TOWN AND COUNTRY PLANNING ACT 1990

APPROVAL REQUIRED BY CONDITION OF PERMISSION

Reference:	H11-0732-24	Date of Decision:	11th October 2024
Applicant:	Mrs F White Strawberry Cottage Millgate Whaplode St Catherine Spalding PE12 6SF		
Location:	Chase Farm 4 Vicarage Lane Long Sutton Spalding		
Description:	Details of boundary treatments, proposed lighting & waste bin designs, location & means of waste collection (Conditions 3, 6 & 7 of H11-0784-23)

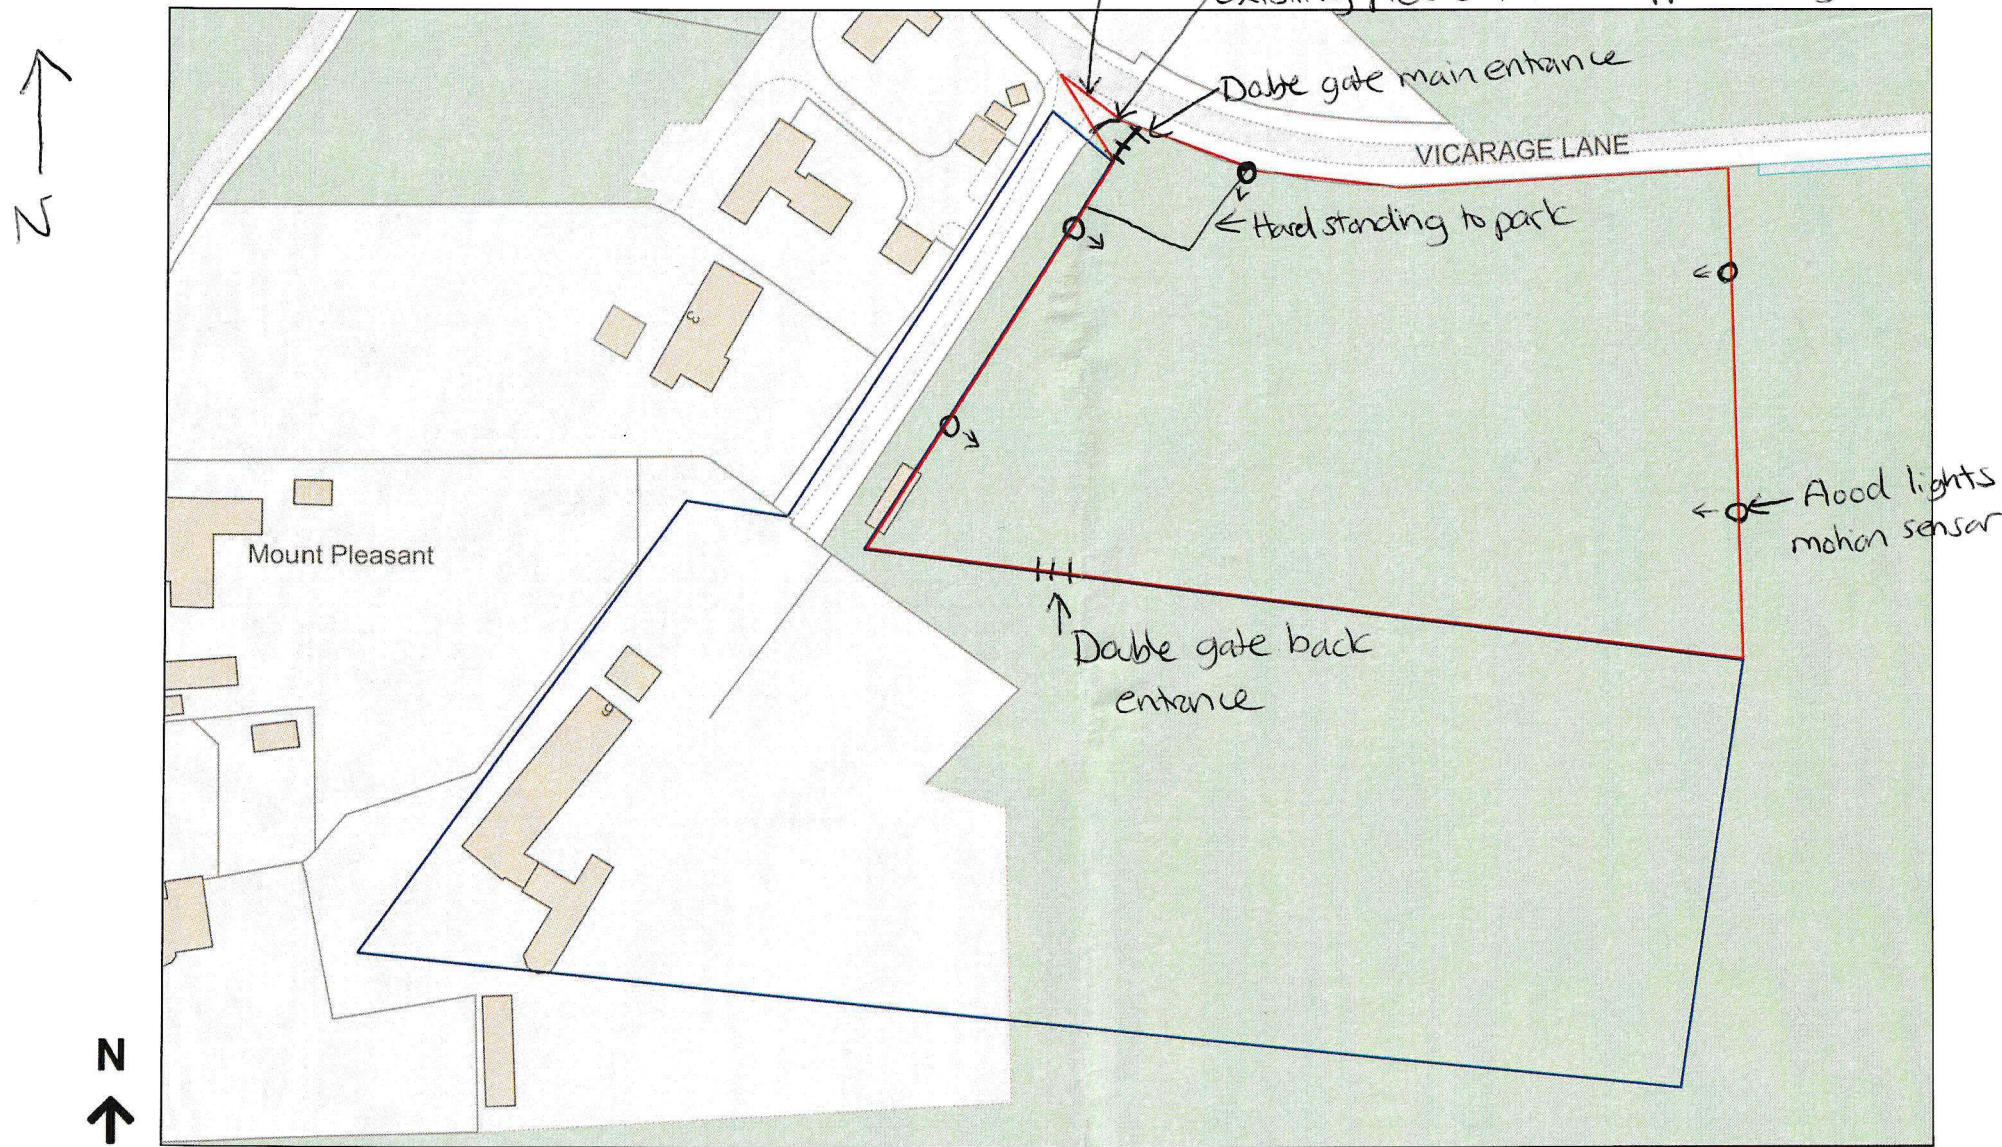
- 1 Insufficient detailed drawings and information have been submitted to adequately show the details associated with conditions 3, 6 and 7 which relate to fencing, lighting and waste bin and collection facility details. The height, design, colour, materials and appearance of the fencing, fence posts, and gates, and if gates are galvanised or powder coated should have been shown at a scale of 1:50 or 1:100 on plans, indicating their position on a scaled block plan showing which sections of fencing, lighting and waste bins are positioned in the locations proposed, and in relation to the position of the entrance gates.

The details require a design which complements the area and is not out of character. Insufficient detail has been submitted in relation to the number, size, position, height above ground, fixing details, if hooded, the direction, spread and angle of the lighting. The design of the lighting would need to demonstrate that light pollution would not occur.

The number, position, height, design and materials of the waste bins have not been provided. Exact details showing the information in plan form is required to discharge the conditions. Waste collection details should have been documented.
